To: Amy Powers, Code Enforcement Officer
From: Jim Seymour *JRS*
Date: February 10, 1997
Subject: Generations - Mercy Hospital, 619 Brighton Avenue

I have reviewed the site construction associated with the building entrance and parking lot improvements for Mercy Hospital's (Generations) 619 Brighton Avenue property. Based on my site visit, I believe a temporary certificate of occupancy can be issued. Prior to any permanent certificate or release of a performance bond, the following items must be addressed and completed:

**2** TYPICAL ADA CURB RAMP  
 SCALE: 1/2" = 1'-0"

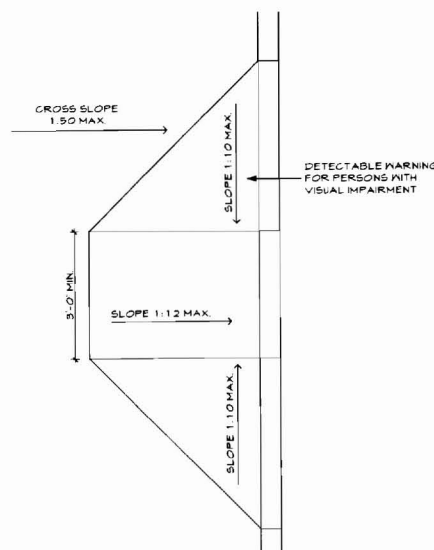
4. A Casco trap or hood shall be placed within the catch basin located in the parking lot prior to June 1st.
5. The areas in front of the handicap access ramp leading to the building entrance shall be constructed such that the lip from the parking area to the ramp meets ADA standards. Currently, a larger lip than normal is there because the final pavement course has not been set. The adjustment may be temporary, but must be installed immediately, or as soon as weather conditions allow for construction.
